SUBJECT: Engineering Review Comment
Mountain View Electric Association Inc. (MVEA)

Project Name: North Bay at Lake Woodmoor Final Plat
Project Number: SF263

Description: Proposed development of 6 residential lots located at Woodmoor Dr. and Deer Creek Rd. in Township 11S, Range 67W, Section 11.

FINAL PLAT
NORTHBAY AT LAKE WOODMOOR

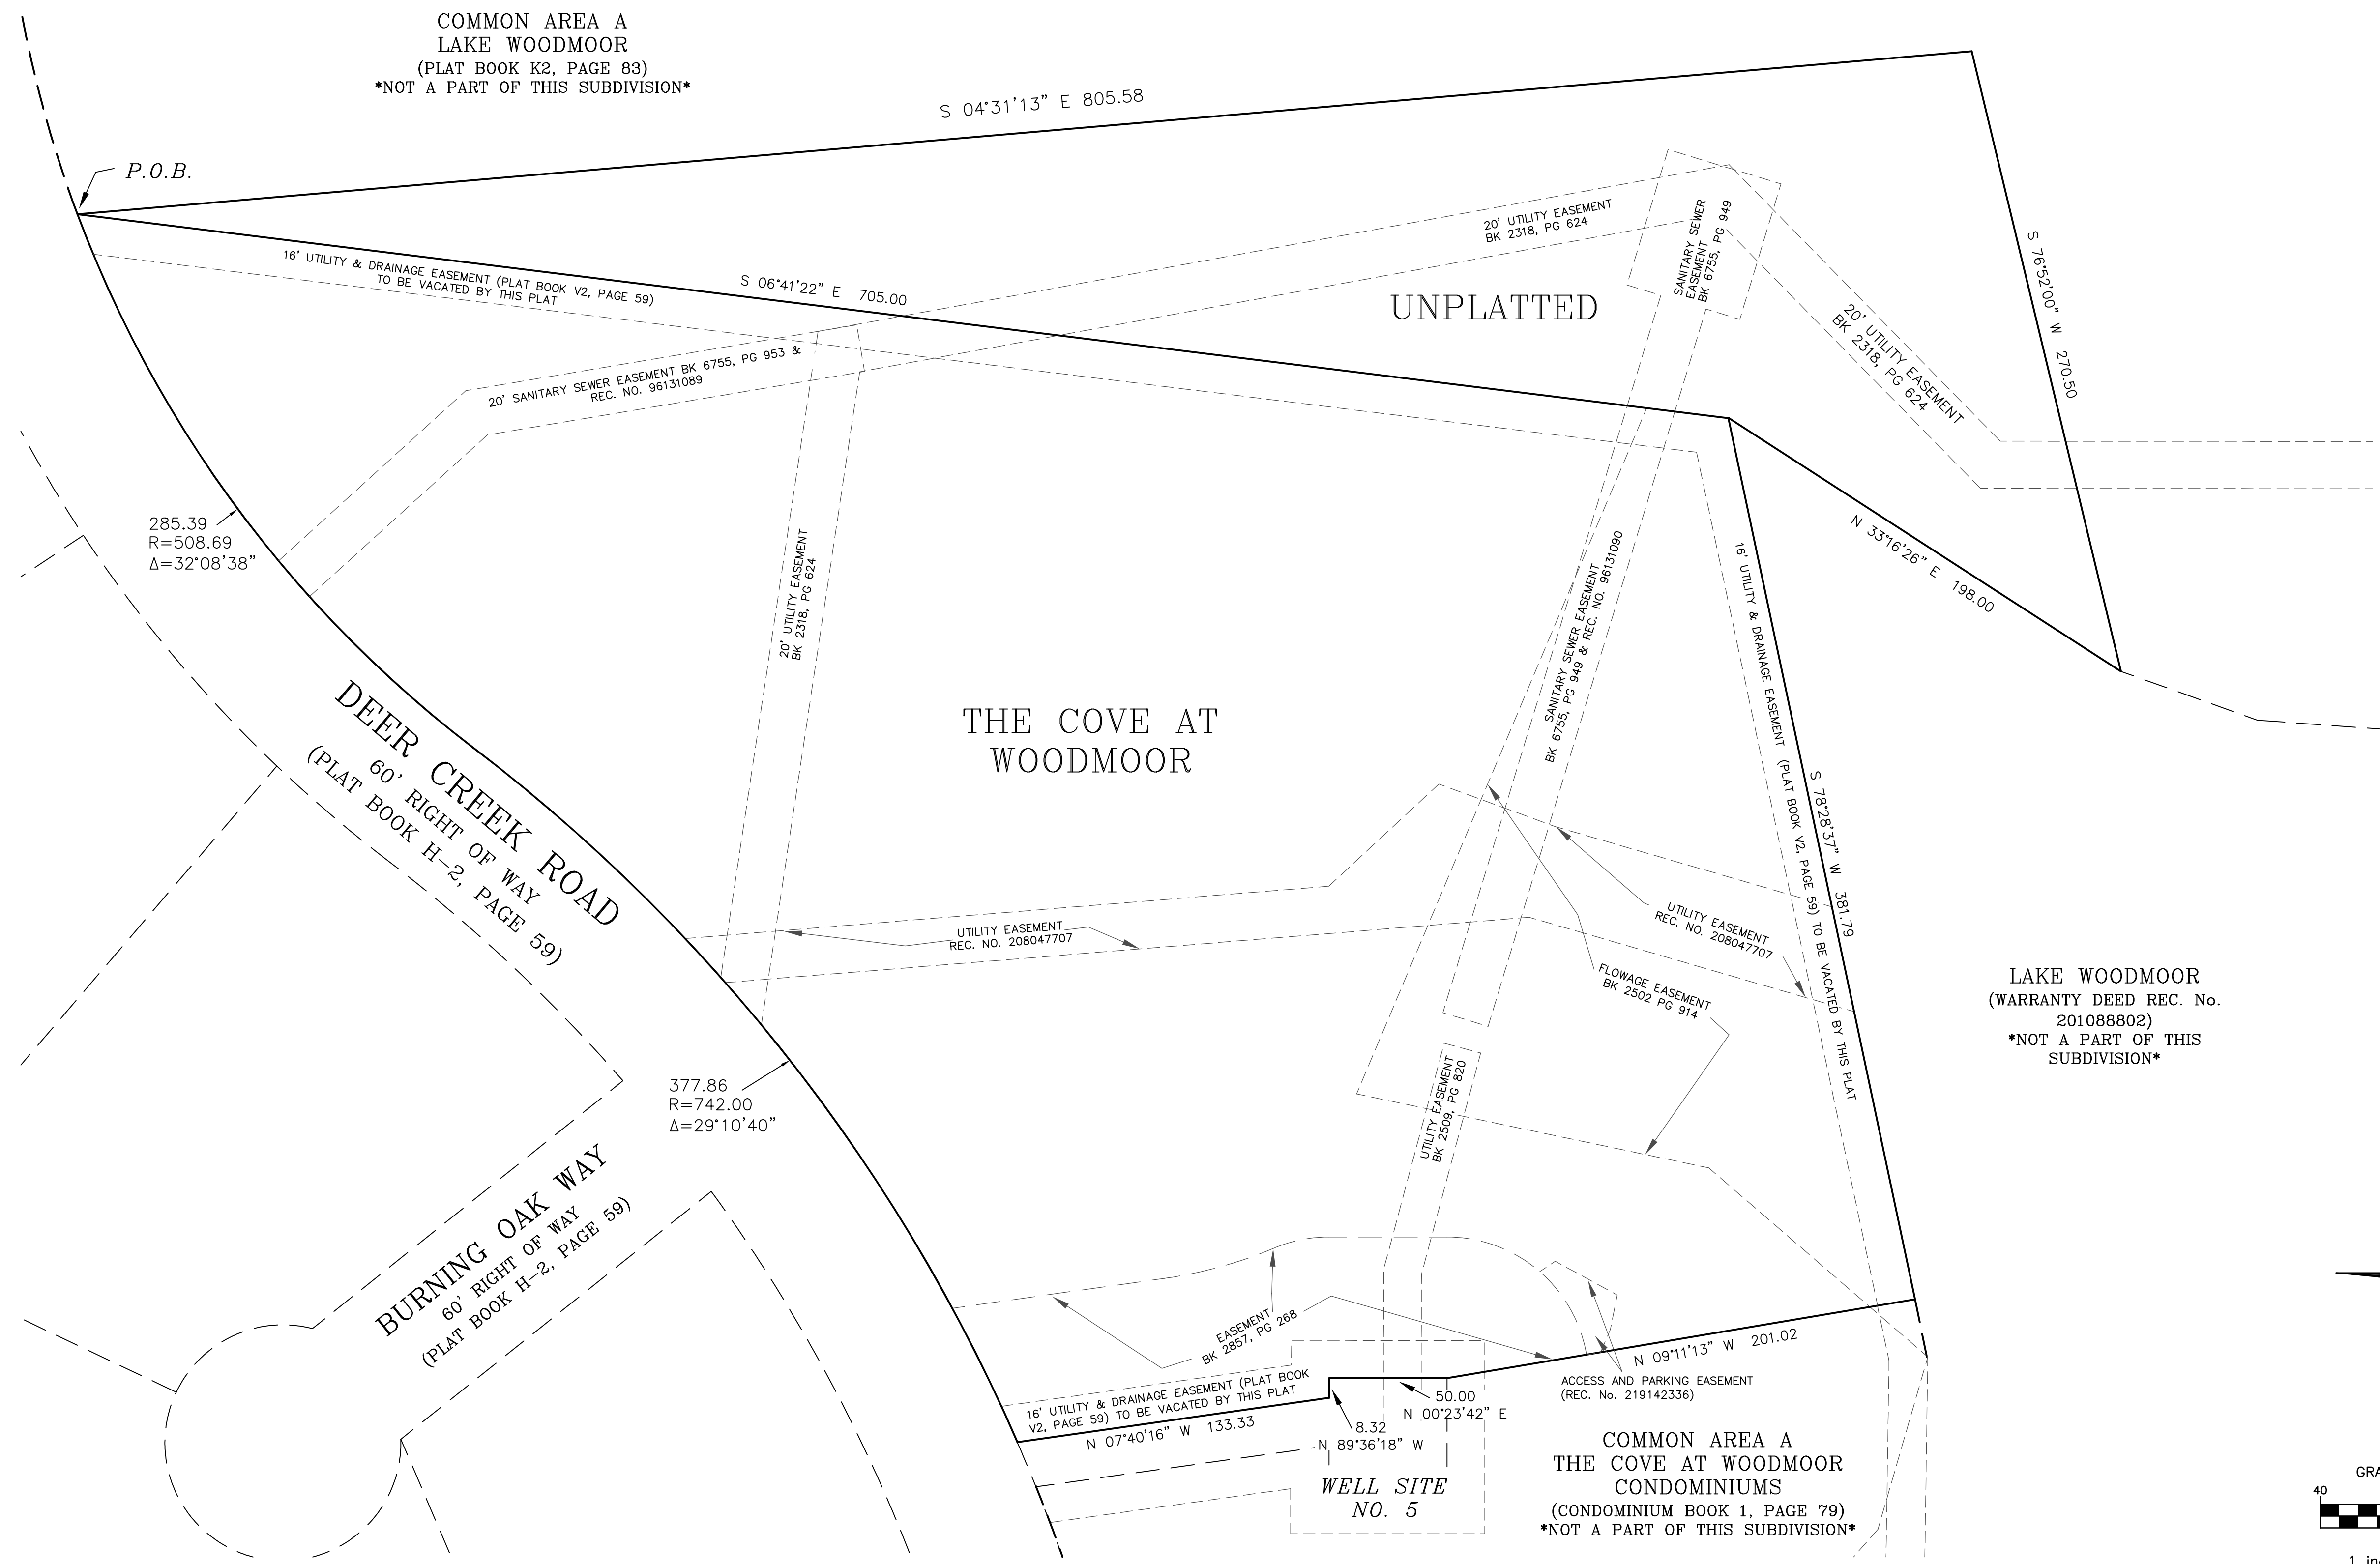
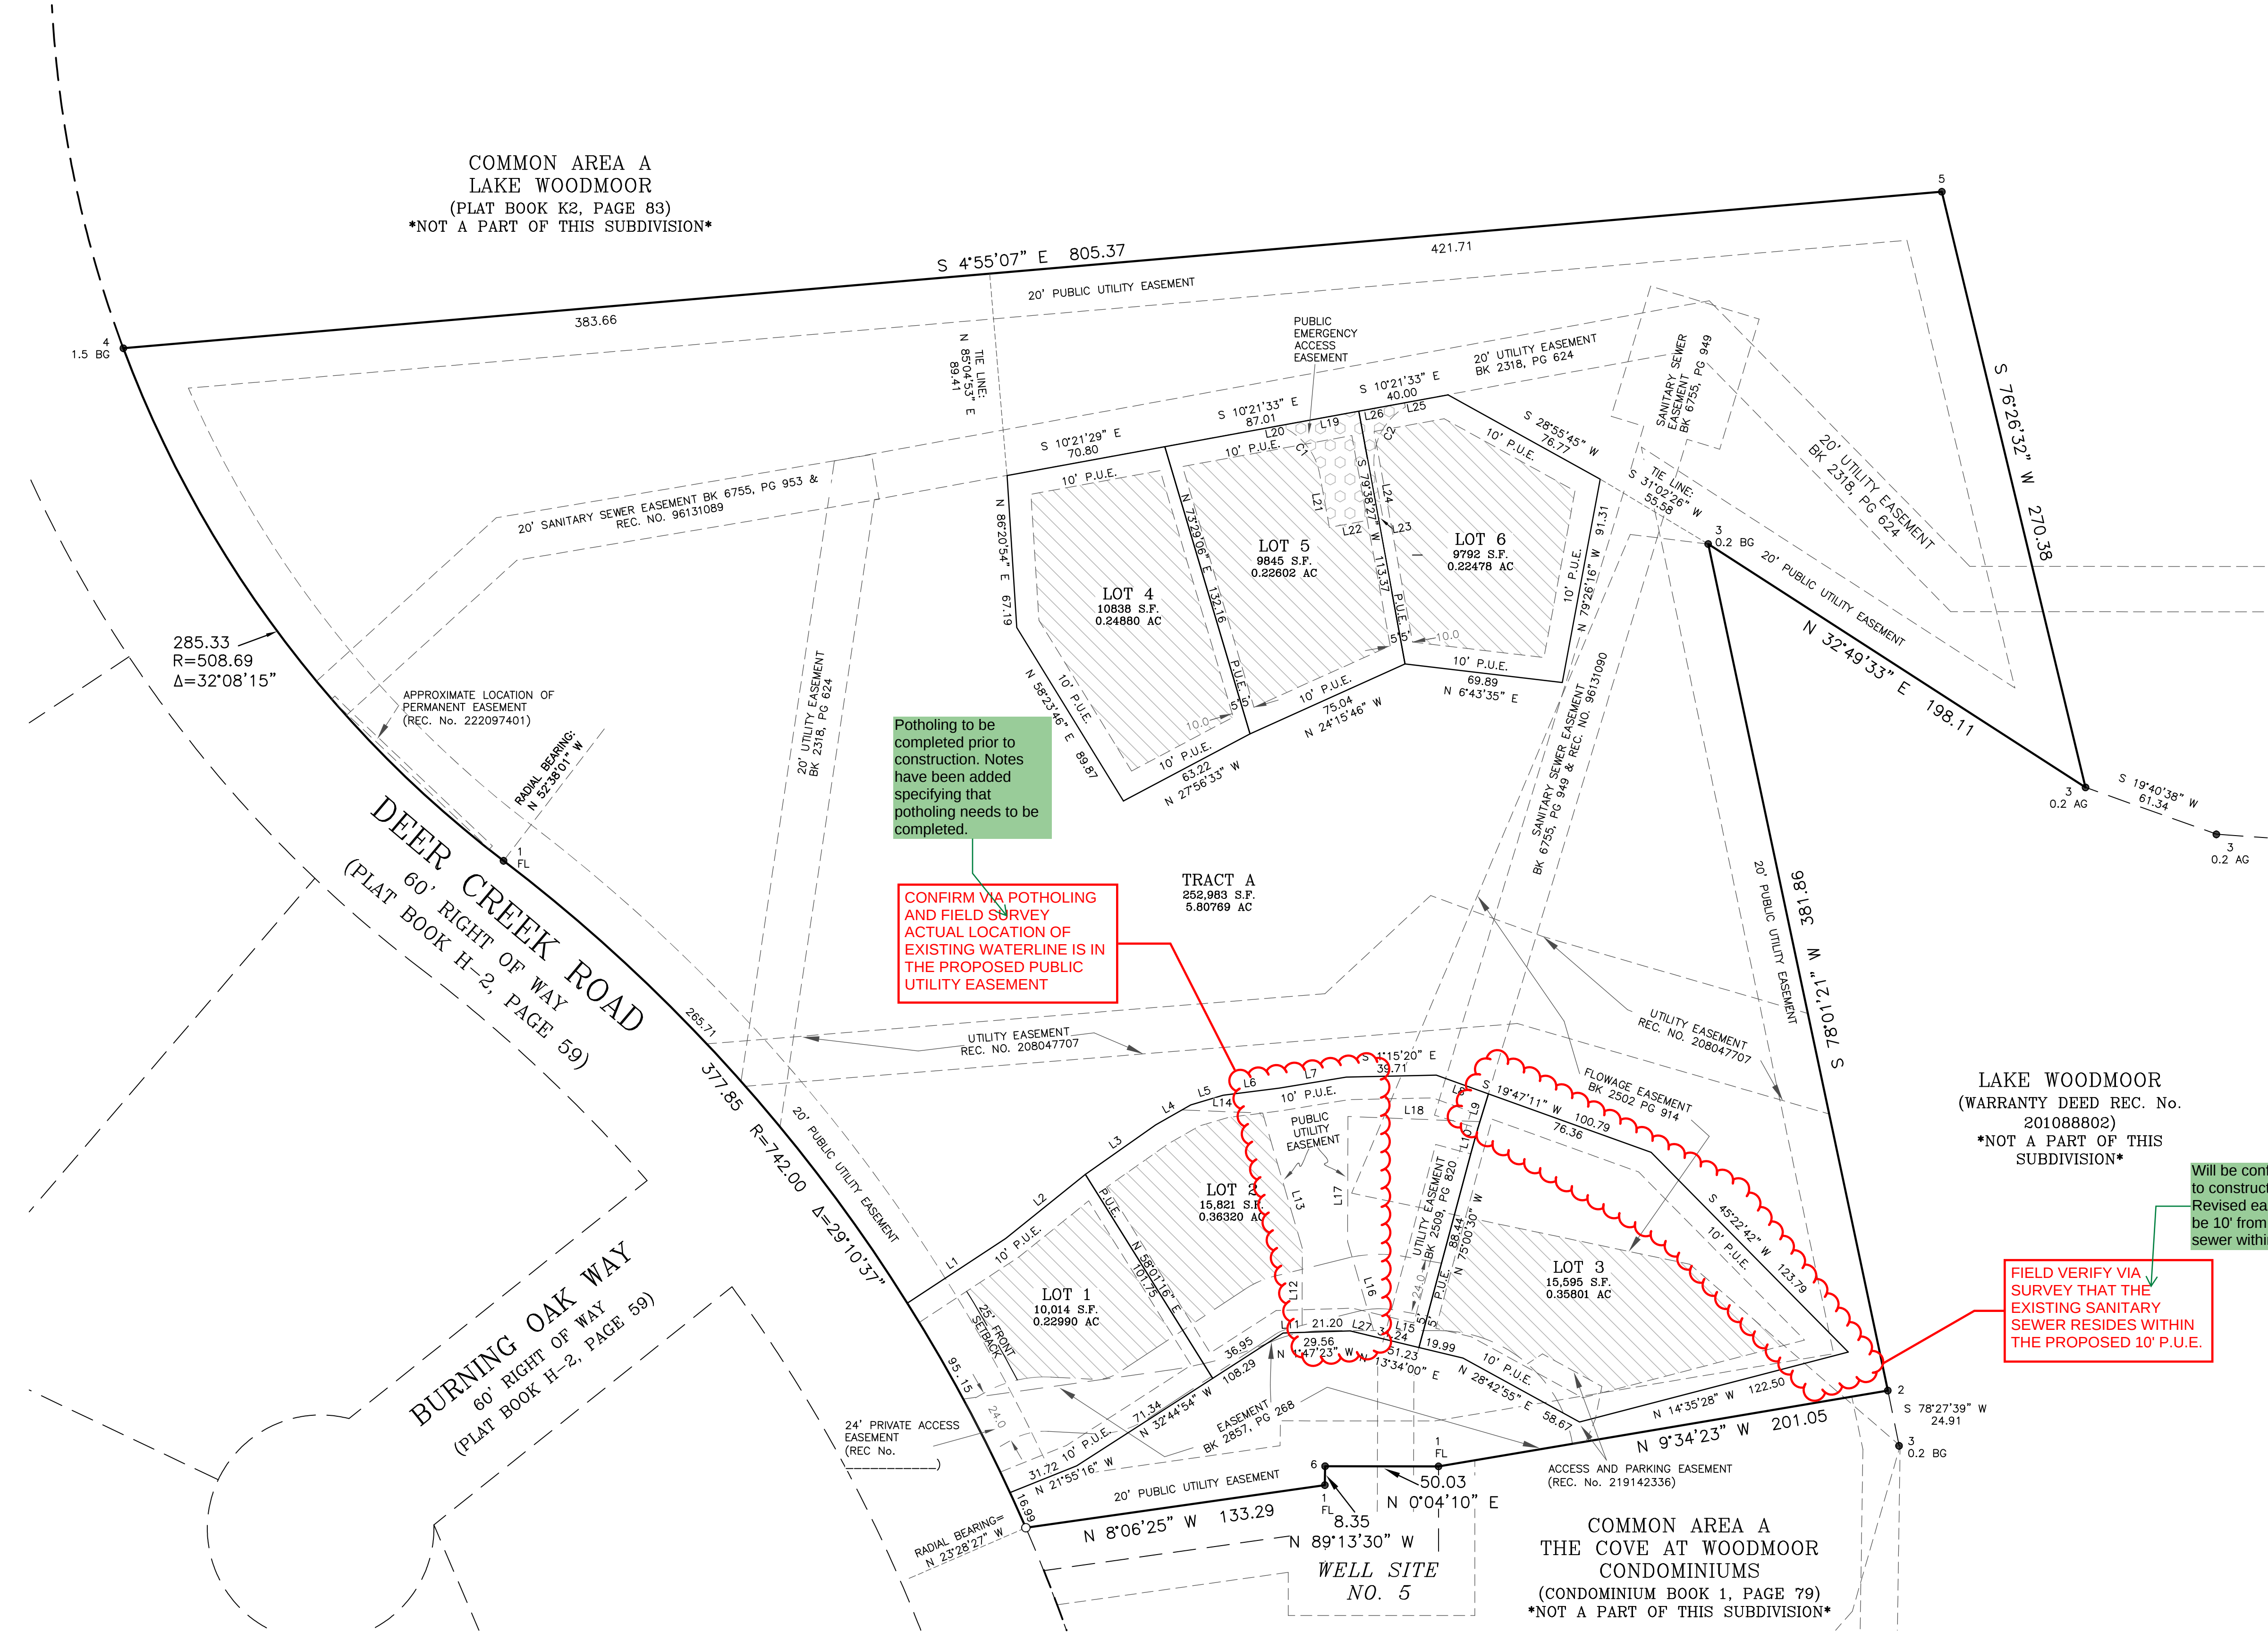
MVEA requests a ten (10) foot front, side, and rear lot utility easement and all tracts, along with a twenty (20) foot exterior utility easement on the plat. MVEA also requests the platting of MVEA's existing facilities with easements on the plat. Additional easements may be required.

MVEA objects to the language included in the easement note on the plat stating: all utility easements that are dedicated hereon for public utility purposes shall be subject to those terms and conditions as specified in the instrument recorded at Reception Number 212112548 of the records of El Paso County, Colorado.

All requested easements are provided with Public Utility and Drainage Easements (P.U.D.E.) on the property.

This note has been removed.
